Subject: Request for Additional Information

Our ref: Gunlake Quarry Continuation Project (SSD-12469087) – Response to RFIs

Map - Gunlake Quarry - Crown land - Previously Closed Road

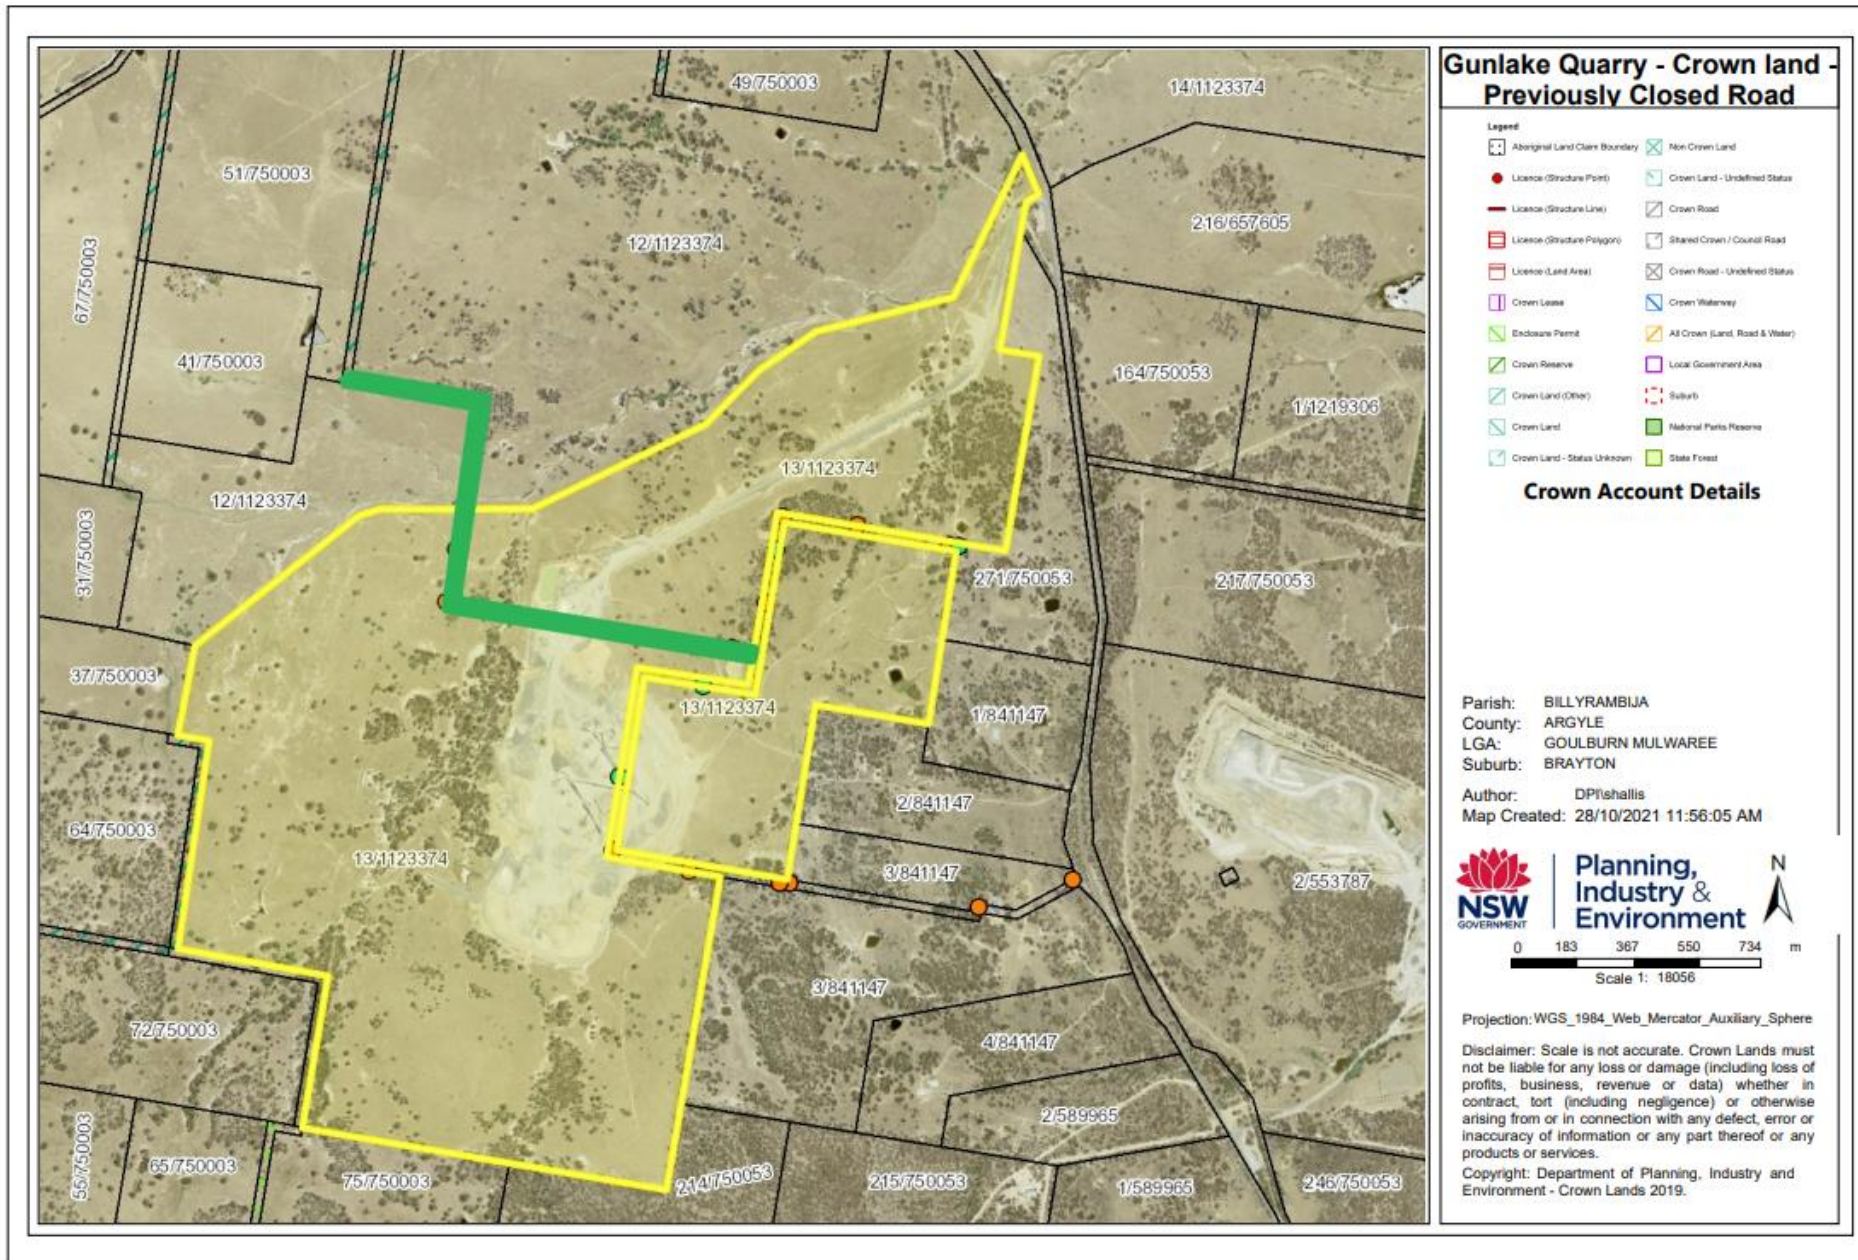
5. Appendix A – in the attached letter from Crown Lands, the address block does contain an address.
